RFI

RFI #: 188
Date: 9/18/2012
Job: EB-02 Keller Springs Lofts
Phone: 877-777-5115

Subject: Conflict between Structural and Architectural's sheets at stair #8

1 DIVISION 'E' ROOF PLAN
1/8"=1'-0"

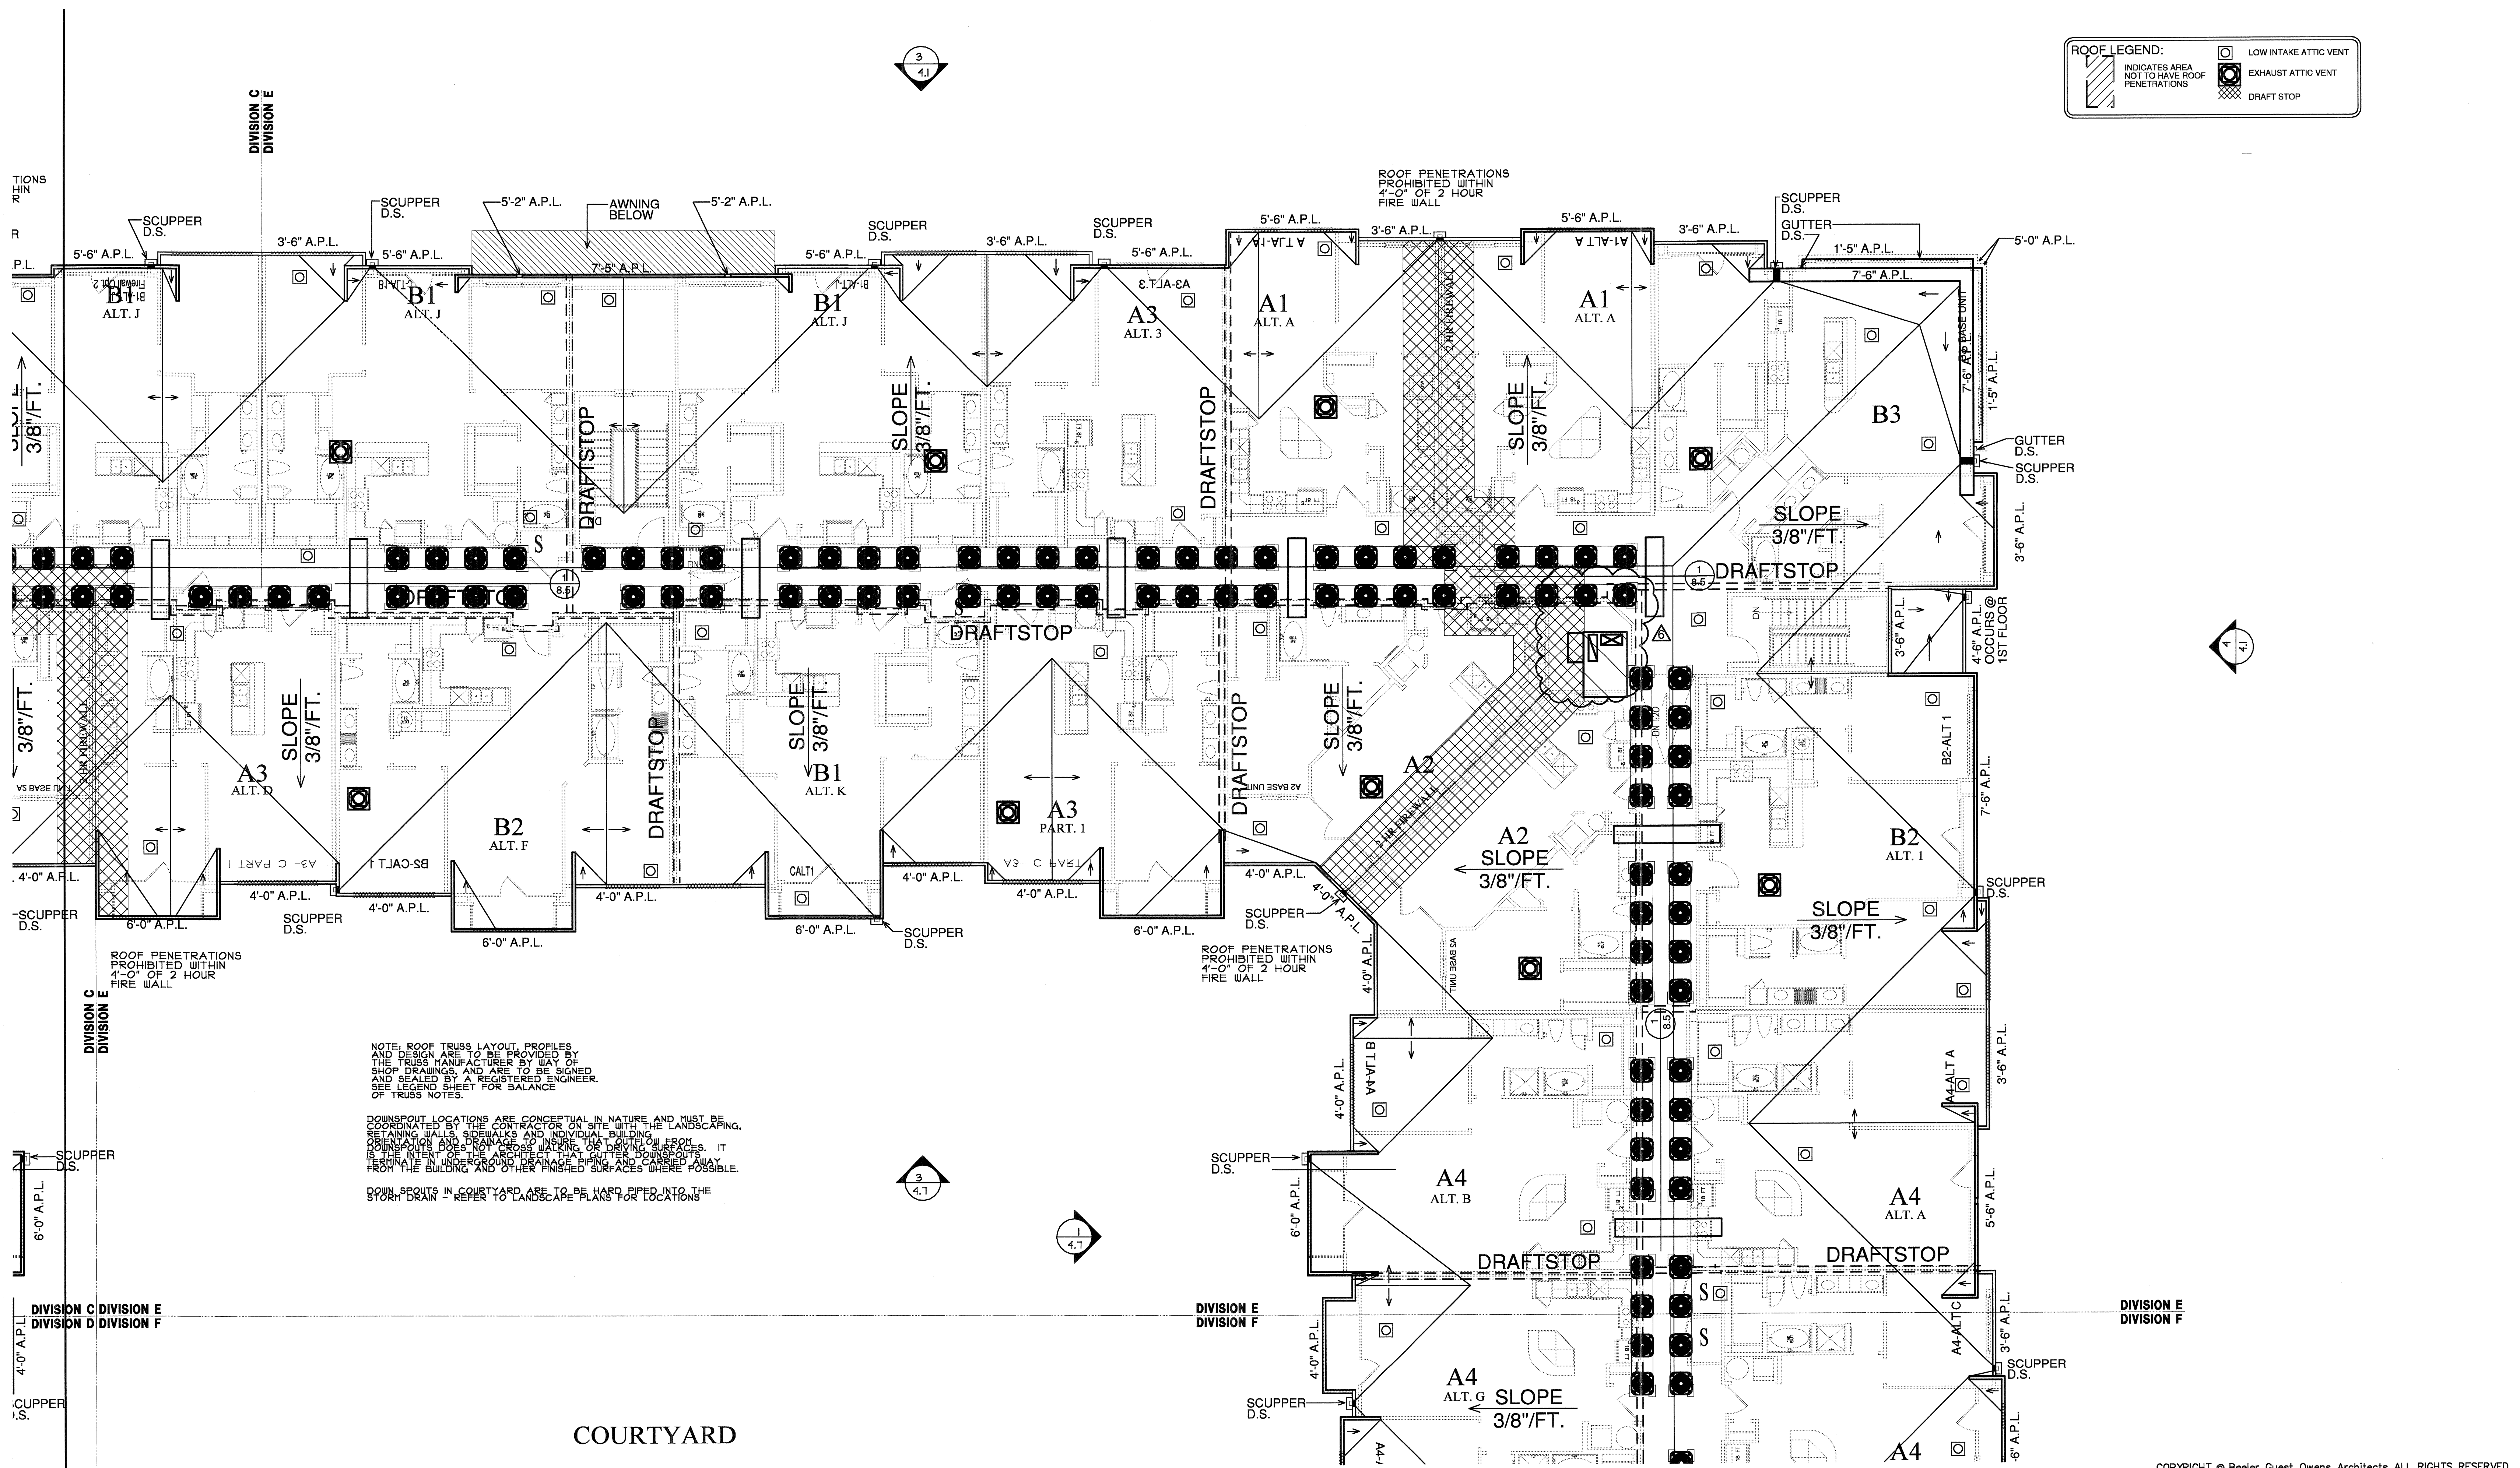
Request: **Date Required:** 9/18/2012
There is a conflict between the structural plans and the architectural's at stair tower #8. See the following and please clarify.
1. S2.25 shows low roof framing over the 1st floor and no storefront at the exterior wall.
2. S3.25 shows no exterior triple window only single window at stairs.
3. S4.25 shows roof deck extending to exterior of building with no window below.
4. 3.2E, 3.3E, & 3.4 E shows clear opening between exterior Q window and stairwell. This clear opening would go from the slab to the bottom of the roof trusses. The exterior storefront and triple windows would match the building elevations on 4.1 & 4.4 and the roof would match 3.5E.
5. There is no stair section in the architectural's to refer to for stair #8. (all other stairs have stair section)
6. Is there a single window AA in stair tower and triple window Q at exterior wall

Response:
Please see sheets S2.15, S2.25, S2.35, and S3.05 re-issued on 10/10/12
